WEST SUSSEX COUNTY COUNCIL CONSULTATION

TO:	Arun District Council FAO: Mr. S. Davis
FROM:	WSCC – Highway Authority
DATE:	24 August 2026
LOCATION:	Land at Woodgate Nurseries Lidsey Road Woodgate
SUBJECT:	AL/67/26/DOC Approval of details reserved by condition under AL/89/24/OUT relating to Condition 32- Construction Management Plan and Condition 33- Construction Traffic Management Plan.
DATE OF SITE VISIT:	n/a (desktop study undertaken for purposes of this DOC application)
RECOMMENDATION:	More Information Required

Revision 'A' dated 31/07/2026 is the version of the Construction Method Statement (including Construction Traffic Management Plan) reviewed.

PROPOSED ACCESS ARRANGEMENT FOR SALES AREA

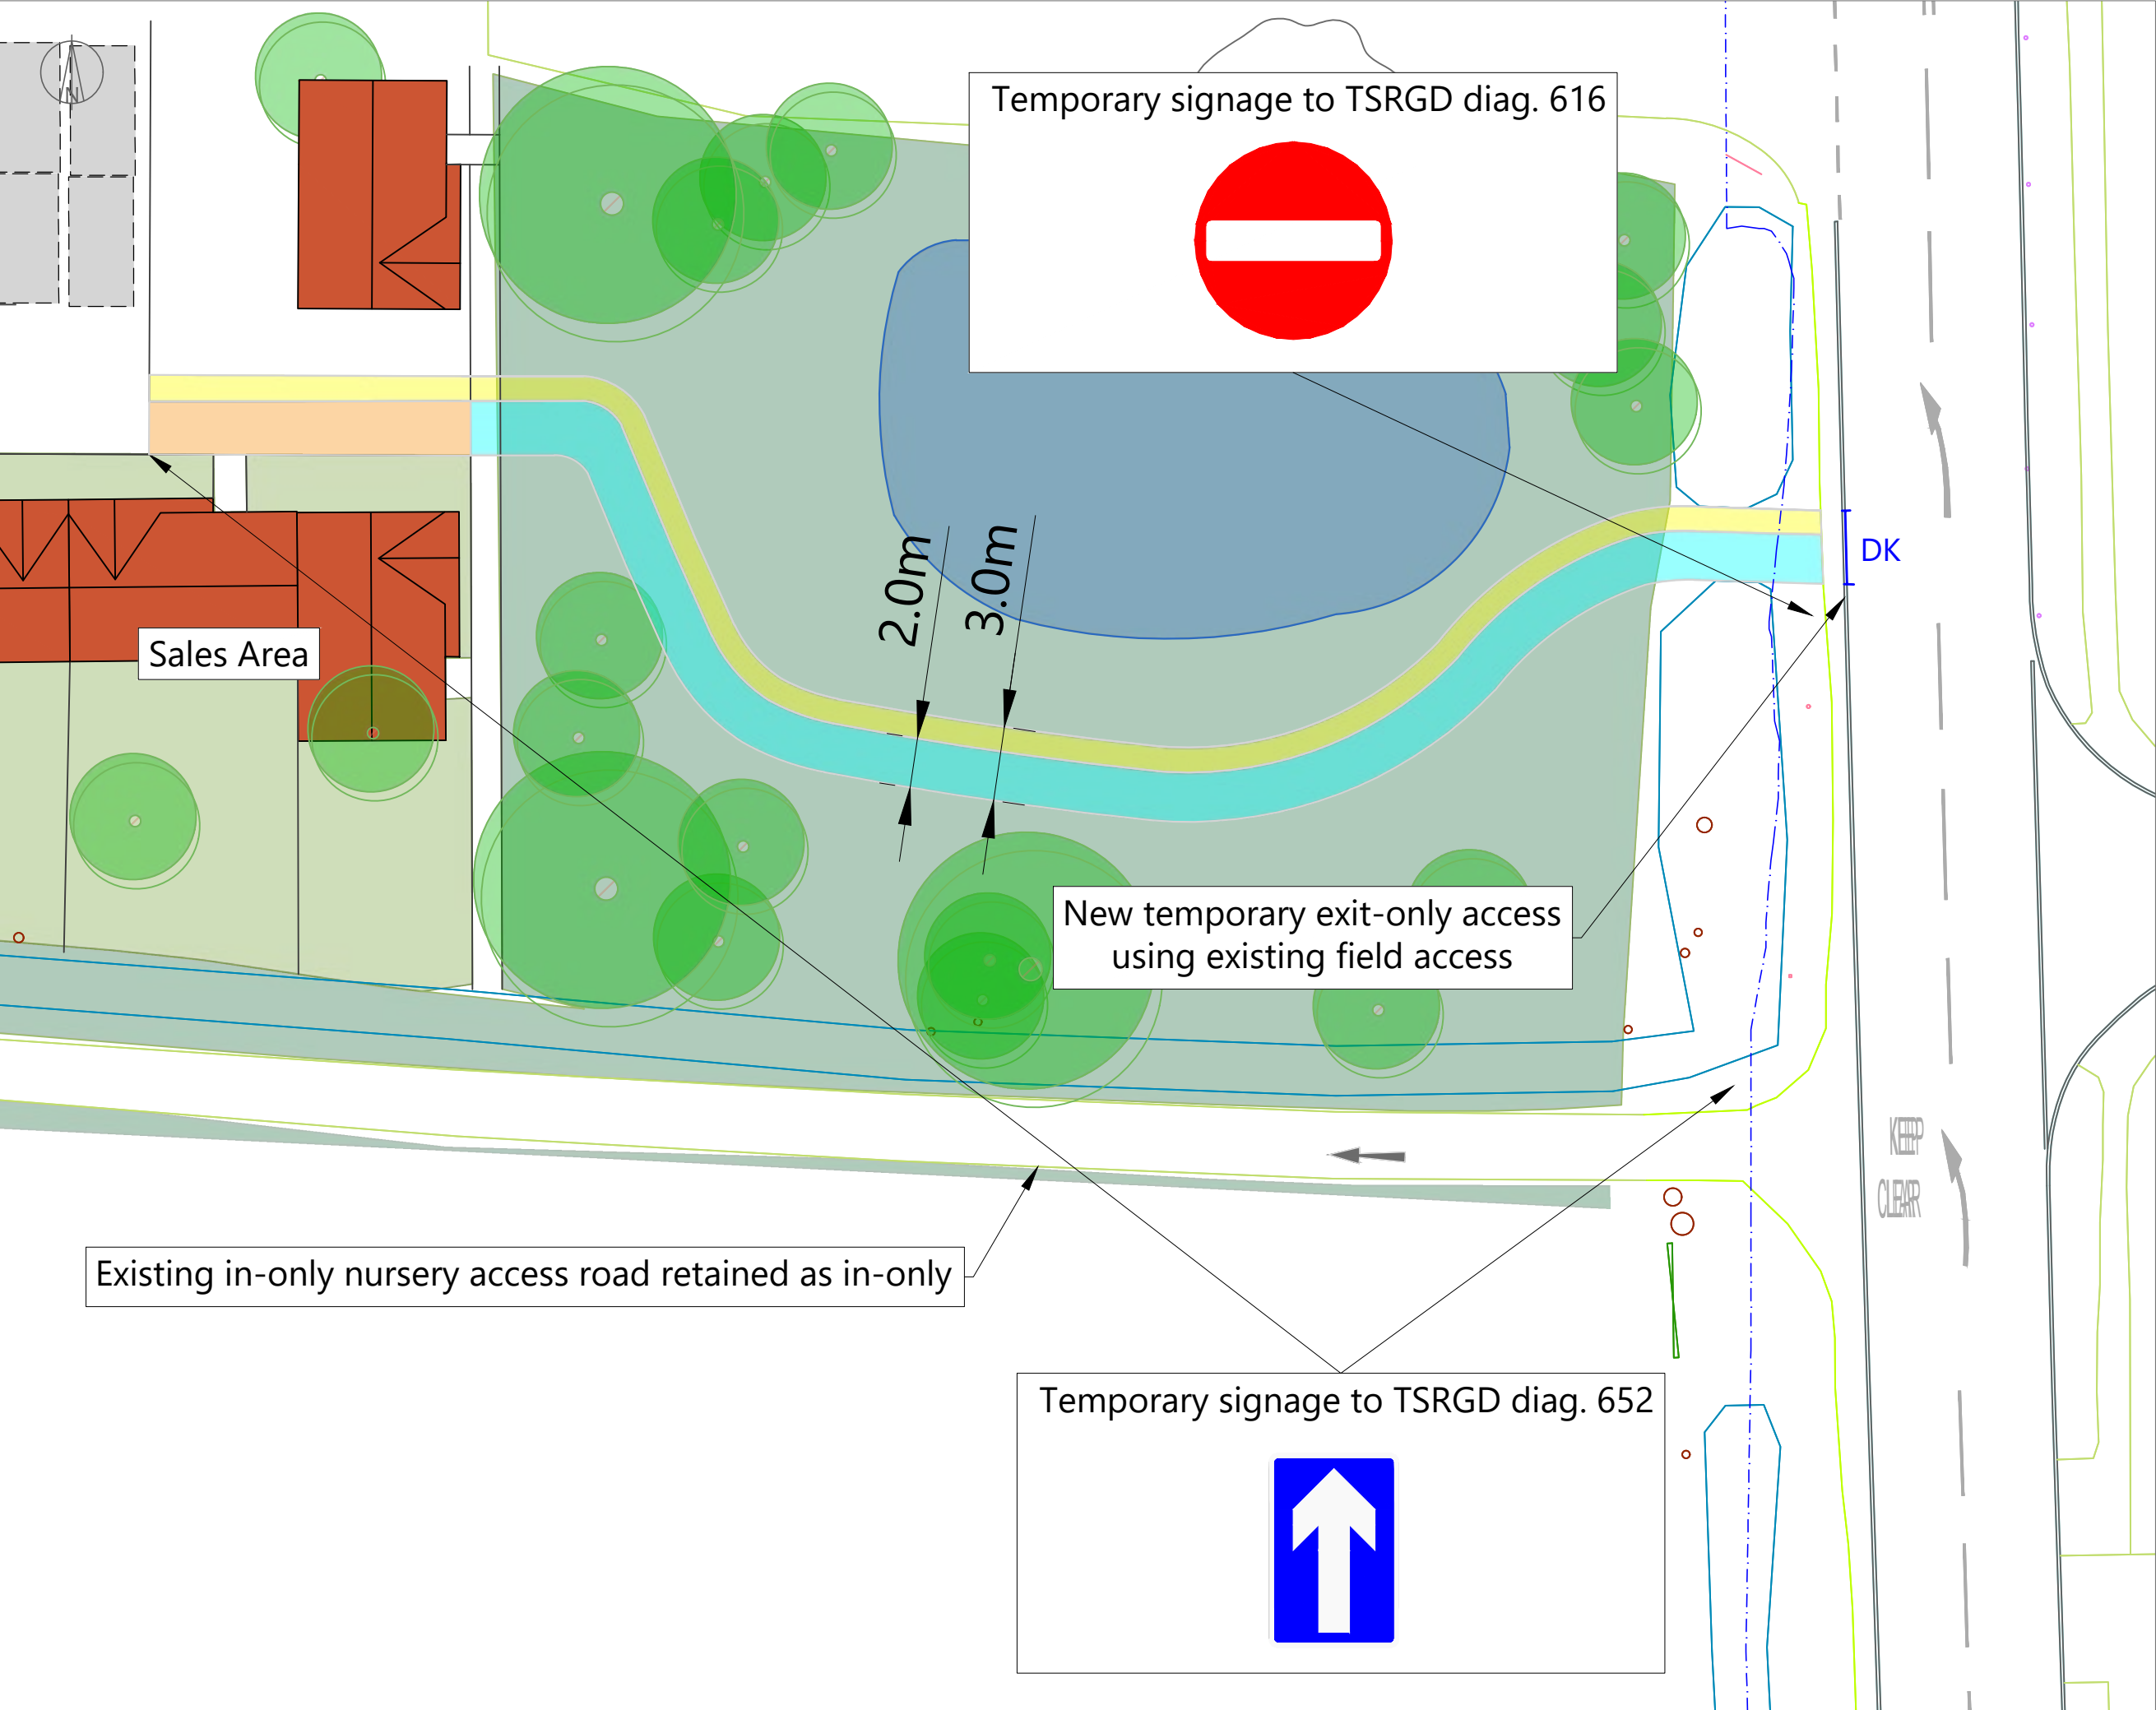
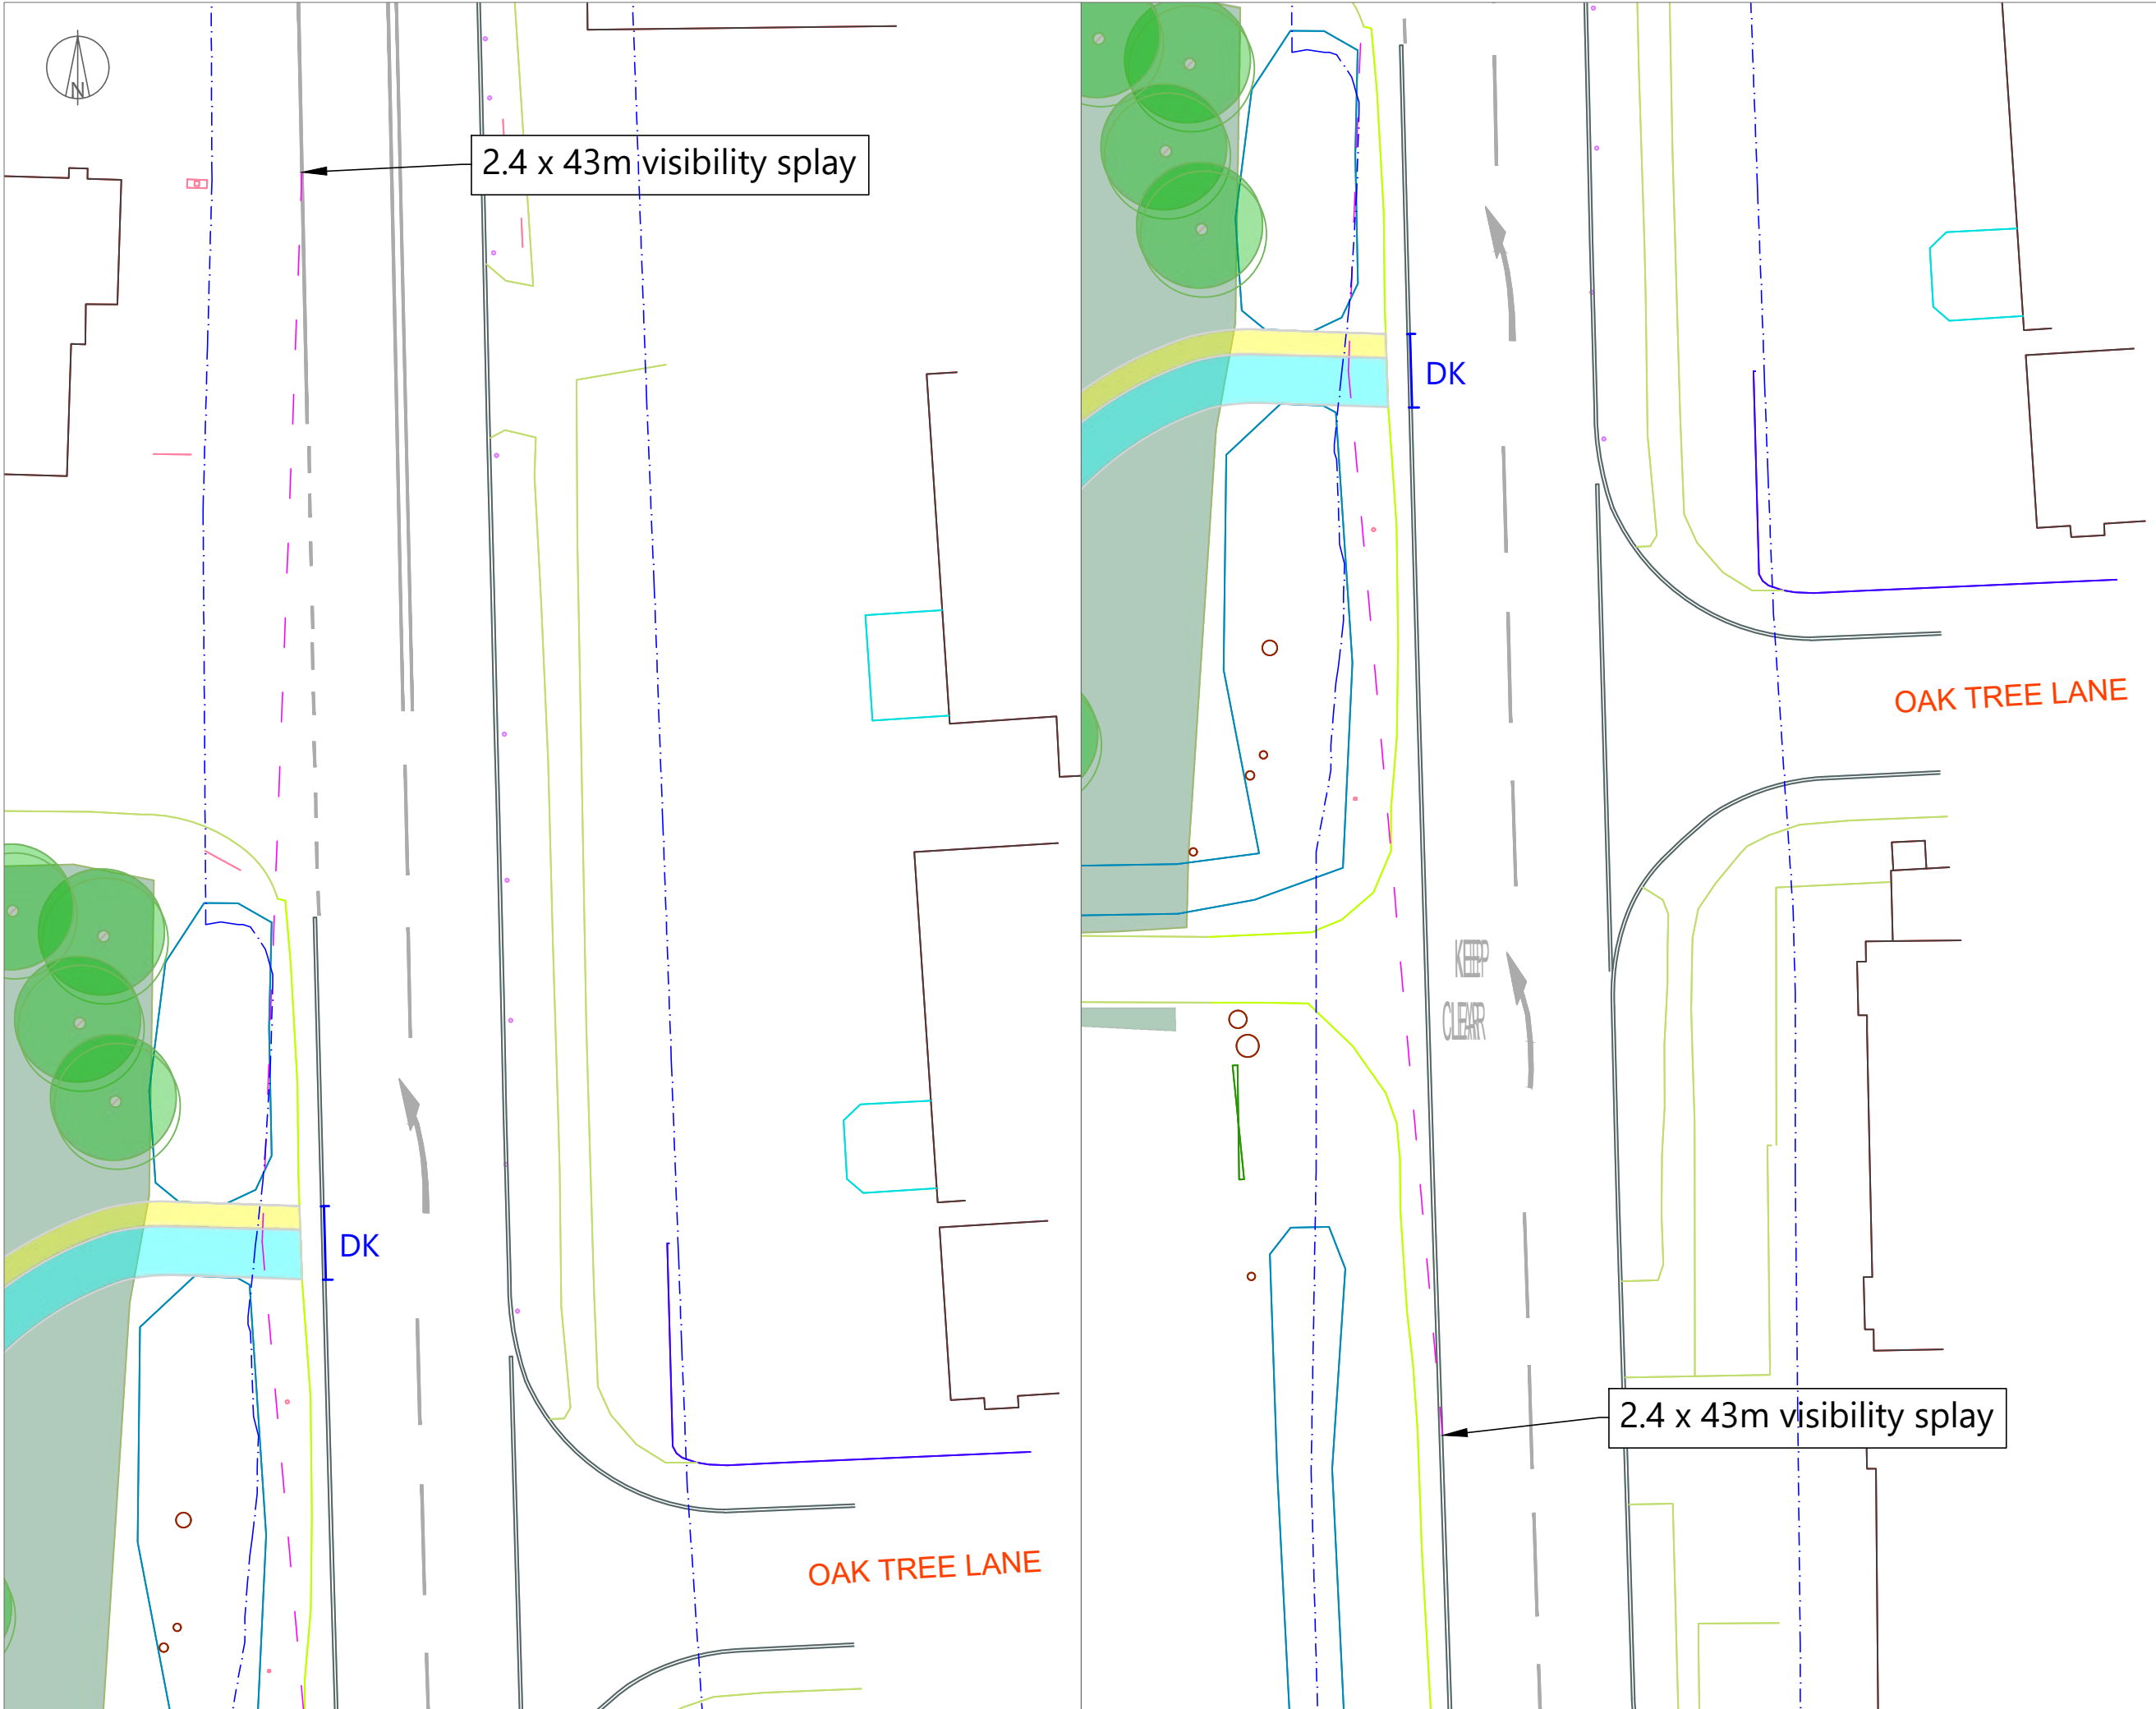
1. In the section where it states that prior to commencing construction works a photographic record survey of the existing highway will be undertaken for the full extent covering the Lidsey Road S278 Works, the document needs to state that the liaison with WSCC will take place prior to the photographic record survey being undertaken to ensure that the details informing the survey follow WSCC requirements – and once agreed, then the survey can take place. This should be confirmed.
2. Out-of-hours contact details need to be included, including confirmation that such details will be displayed prominently on Heras/boundary fencing surrounding the site, viewable to third parties.
3. Visibility splays (including pedestrian visibility splays) must be provided at the exit point onto Lidsey Road for the sales office, and shown as such on a plan to be appended to the final CMS.
